**PLANNING DEPARTMENT
DEVELOPMENT SERVICES DIVISION
600 2nd Street NW, Ground Floor, 87102
P.O. Box 1293, Albuquerque, NM 87103
Office (505) 924-3946**

OFFICIAL NOTIFICATION OF DECISION

**Project# PR-2019-001983
(1004228, 1002571, 1003853, 1008564)
Application#
SD-2020-00206 PRELIMINARY/FINAL PLAT**

For all or a portion of: **LOT A-1 & A-2,
GUTHRIE COMMERCE PARK** zoned NR-LM,
located at **600 MONTANO RE NE between
EDITH BLVD and MONTBEL LP** containing
approximately 7.4387 acre(s). (F-15)

PLAT OF
TRACT A-1-A
GUTHRIE COMMERCE PARK

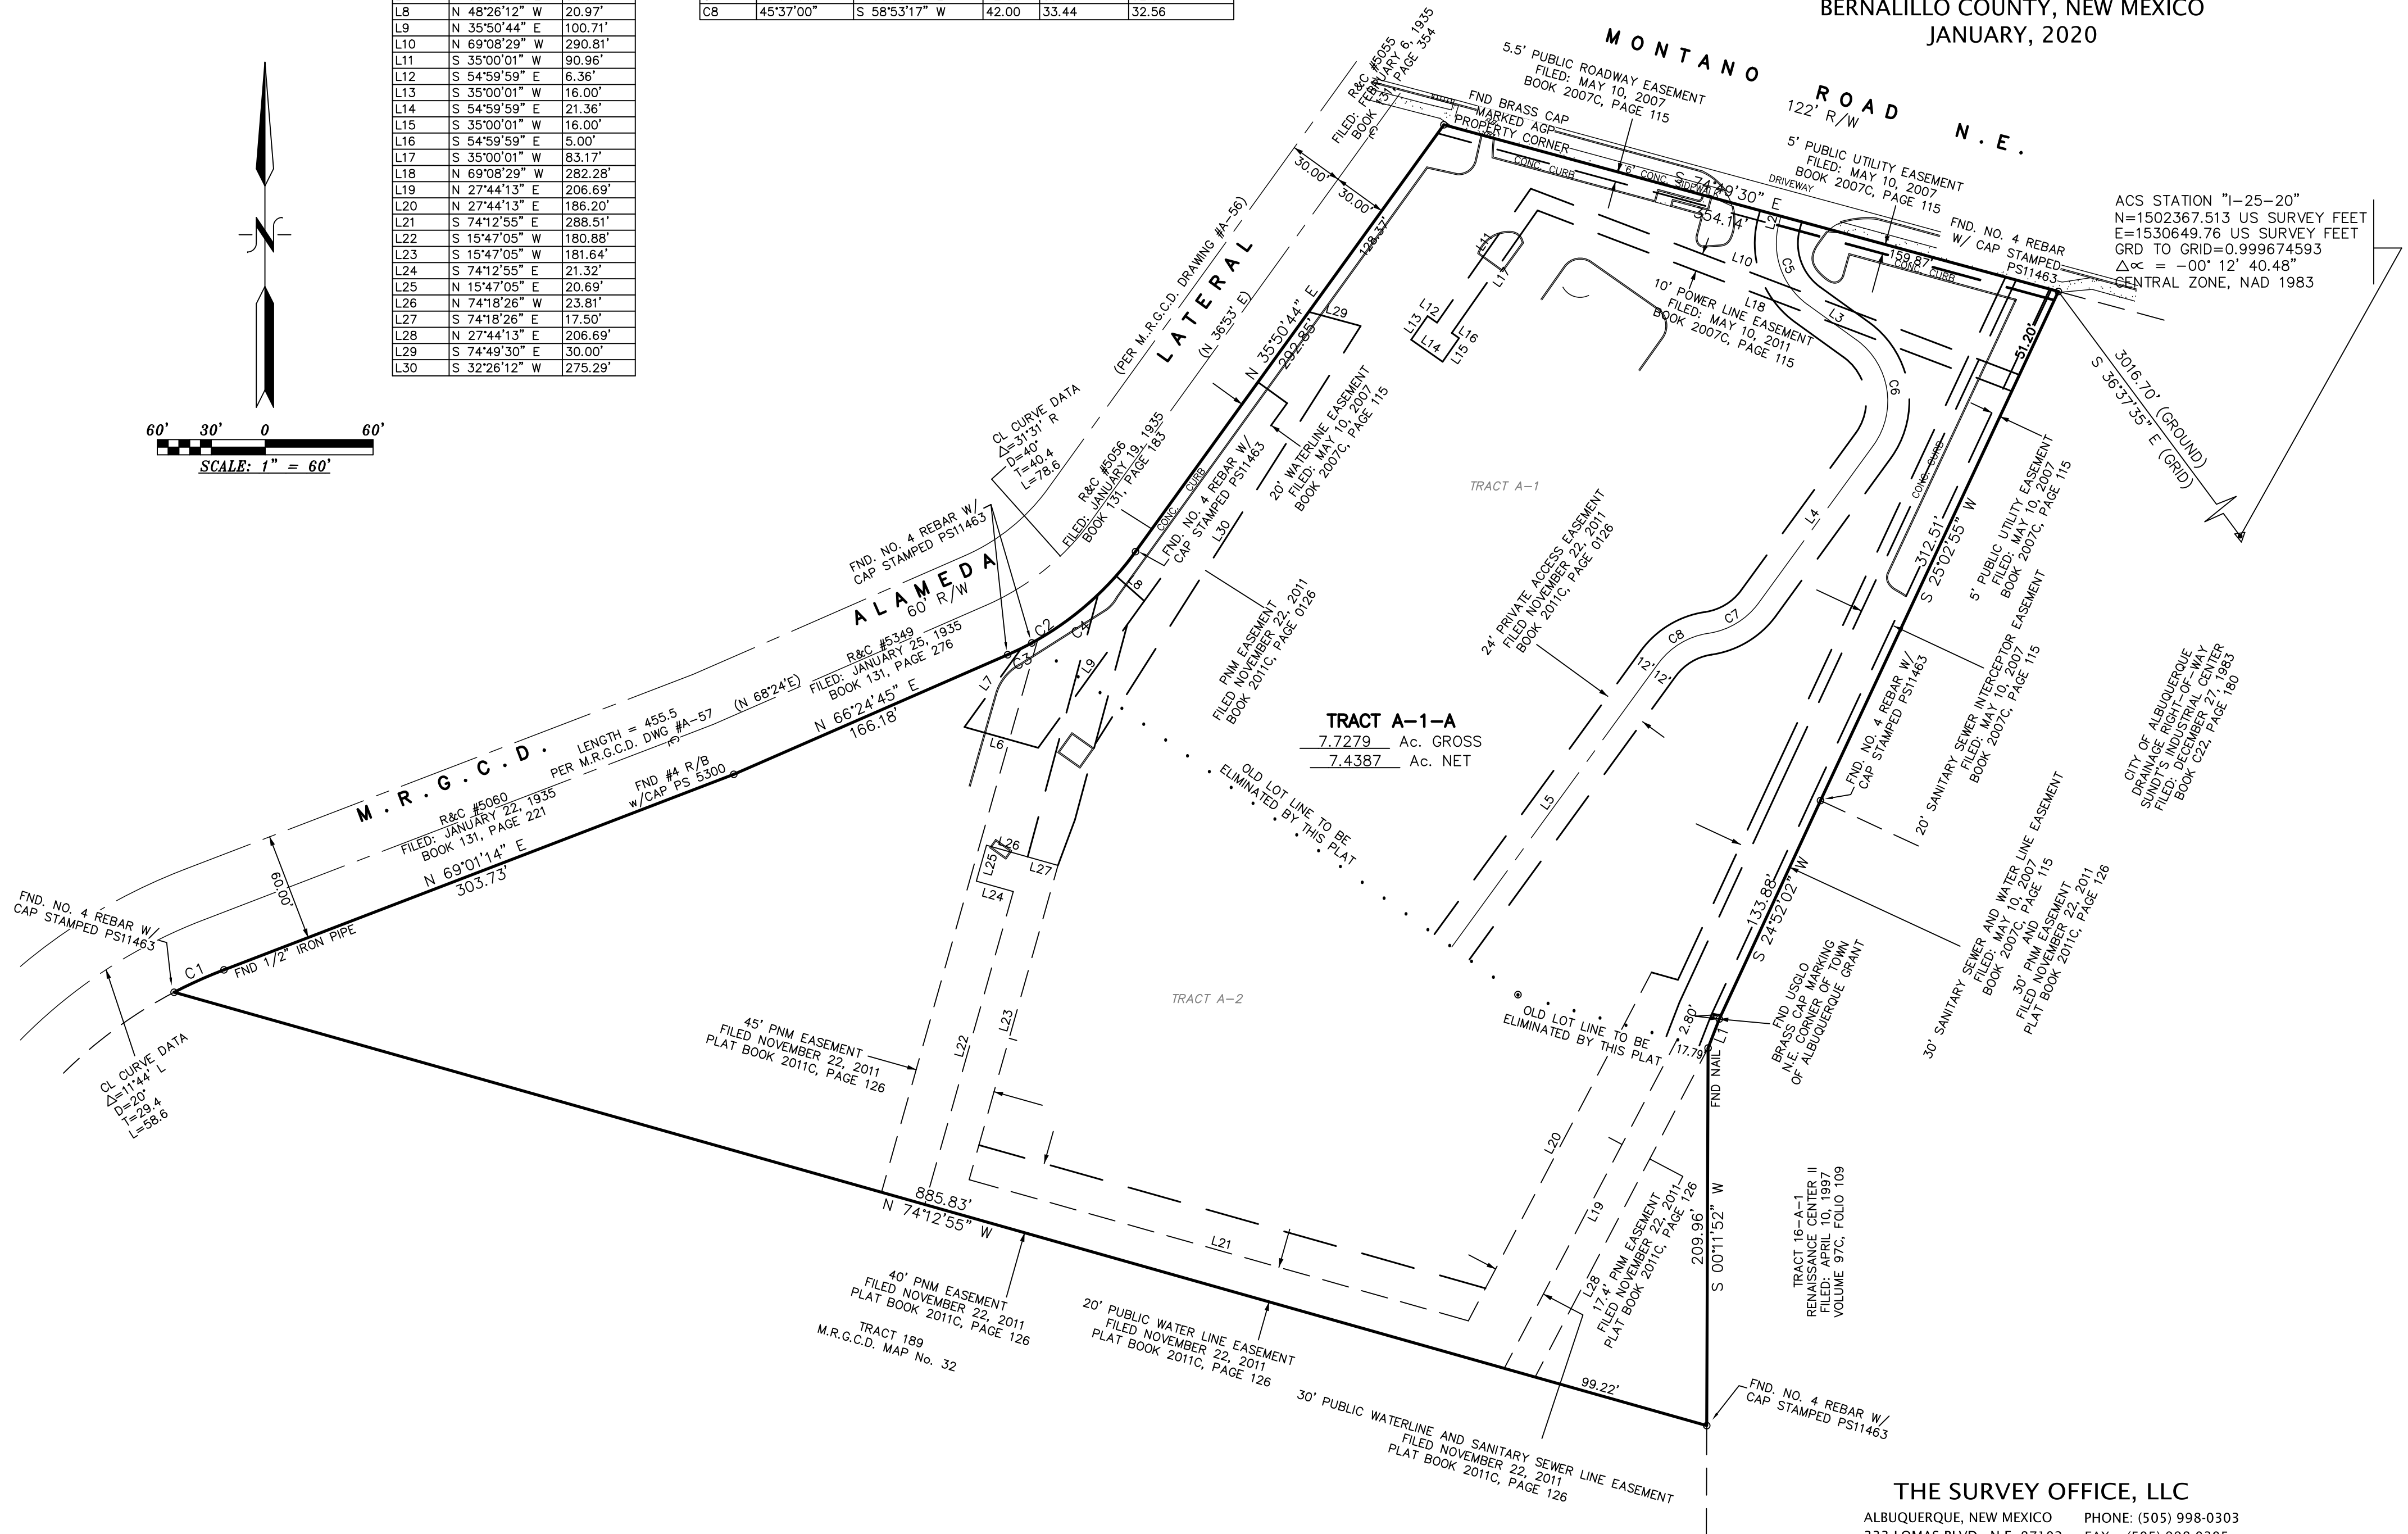
1. Final sign-off is delegated to ABCWUA for the addition of a label to the waterline easement along the north/south alignment of the Site.
2. Final sign-off is delegated to Planning for the AGIS DXF file.
3. The applicant will obtain final sign off from Planning by February 2, 2021 or the case may be scheduled for the next DRB hearing and could be denied per the DRB Rules of Procedure.
